From: Gregg, Robert <Robert.Gregg@lancashire.gov.uk>
Sent: 31 October 2018 13:10
To: Adrian Dowd
Cc: planning; LHS Customer Service
Subject: APP. 3/2018/0958 - THREE MILLSTONES INN, WADINGTON ROAD, WEST BRADFORD

The application is for the retention of unauthorised alterations at first floor to create five guest bedrooms.

FIRST FLOOR PLANS

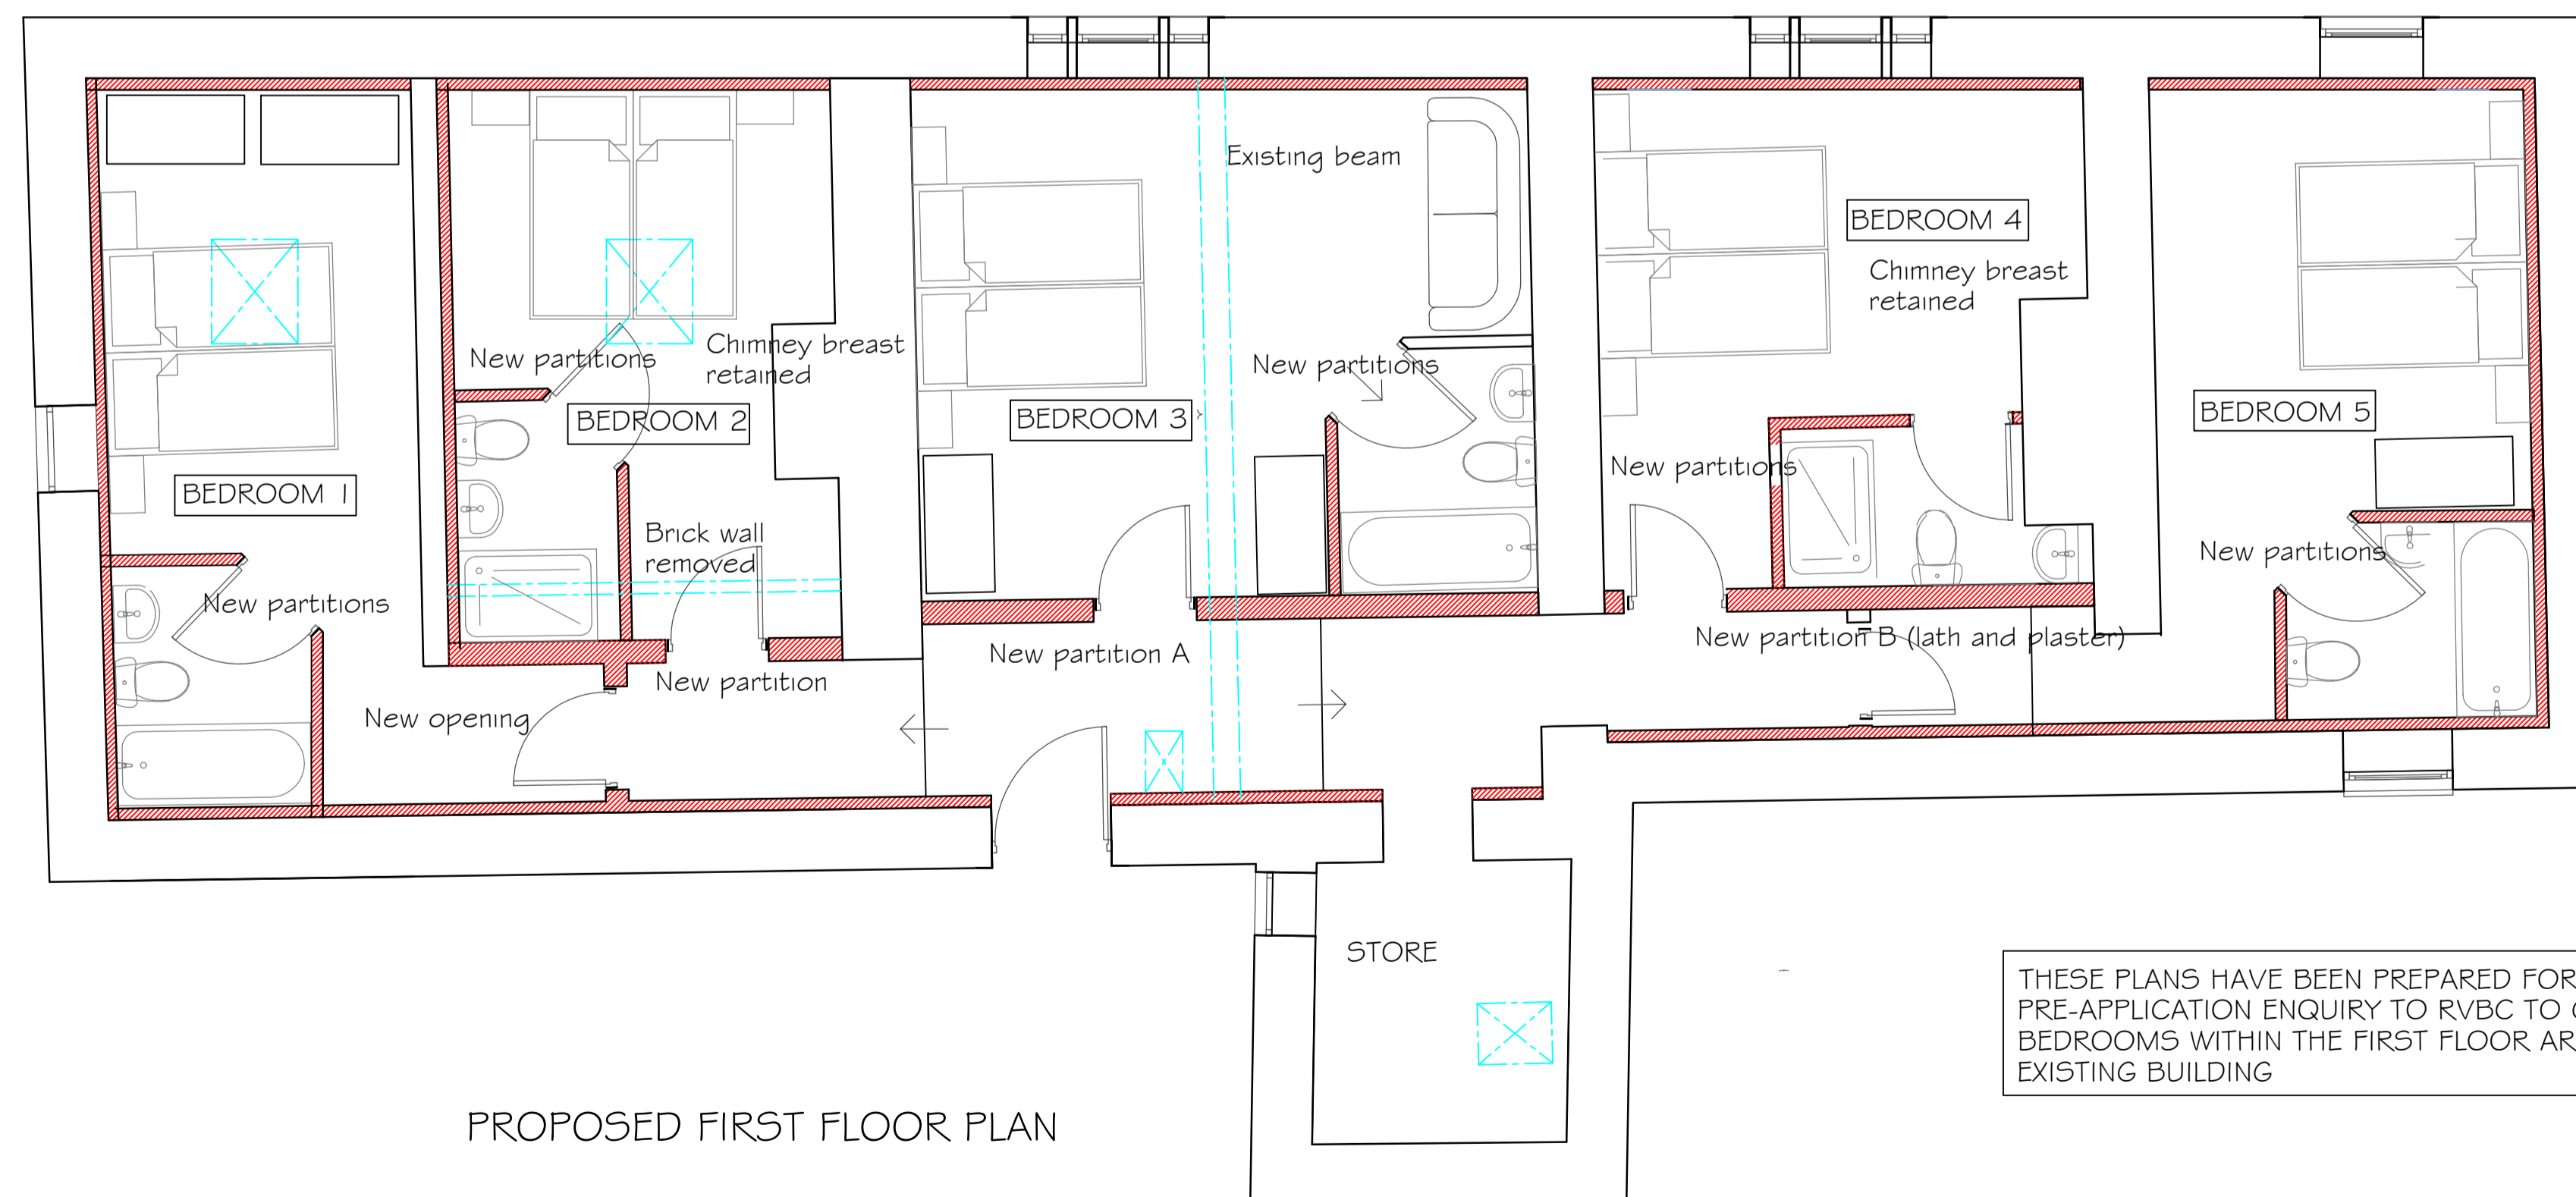
The proposal will result in the creation of a further 5 bedrooms for guests staying at the three millstones inn, the proposal will likely generate more business and as a result of the new 5 guestrooms the parking provisions would increase and based on the parking standards set out by the joint Lancashire structure plan, there will be a requirement for a further 5 parking spaces as a result of this proposal.

- 5 parking spaces for the existing 5 bedrooms
- 14 parking spaces for any customers using the restaurant and bar area and this shall be inclusive of staff parking also
- 5 parking spaces for the proposed 5 bedrooms

A combined total of 24 parking spaces would need to be readily available for the staff and any customers visiting the three millstones inn as a result of the proposal.

I would require clarification as to whether this can be achieved in a detailed revised plan.
